SUFFOLK ENERGY ACTION SOLUTIONS'
REBUTTAL TO NGET RESPONSE TO SEAS RR
NOISE and VIBRATION

SEA LINK: EN020026

DEADLINE: 2 – December 9, 2025

APPENDIX to RUPERT TAYLOR LETTER of 9 December 2025

Plate 1.2 Indicative 3D view of Proposed Saxmundham Converter Station

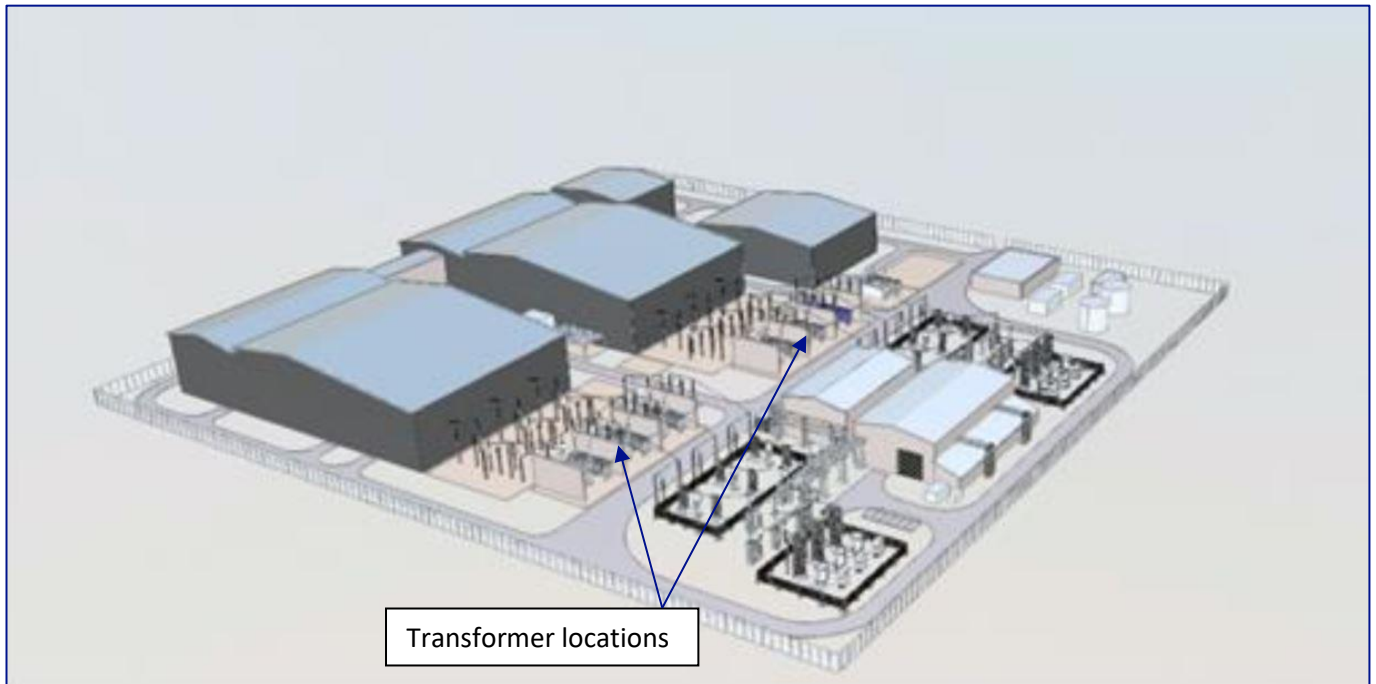
2.3.1 Appendix 2.9.D or APP 138 Table 1.4 p9 lists A-weighted sound power levels for six converter transformers but omits the octave band frequency content (APP-138, p. 9). This is critical because transformer noise is dominantly tonal at 100 Hz & 200Hz (ie harmonics of the base AC frequency of 50Hz), but not necessarily across the wider frequency spectrum.

2.3.2 The authors claim use of ISO 9613-2:2024 for propagation modelling. This standard allows substitution of 500 Hz attenuation values, only if no spectral data are available. Without stating the actual frequency used, the ES may default to 500 Hz, thereby producing an optimistically low noise prediction.

2.3.3 "...shifting the frequency of the transformer from 100Hz to 500Hz results in an over-optimistic prediction..."

2.3.4 This potential modelling error may have significant implications for realworld intrusiveness.

Octave band data was not provided for the transformers due to their potential for variation in spectral content between different transformers, particularly, as suggested at the 100 Hz frequency. Transformers were modelled with all sound power assumed to be at 100 Hz a worst-case, and not at 500 Hz. In practice, the acoustic energy at 100 Hz would be expected to be in the order of 10 dB lower, with the difference spread to higher frequencies.

Higher frequencies will be subject to greater attenuation by an acoustic enclosure than occurs at 100Hz, tending to increase the prominence of the 100Hz content in the spectrum
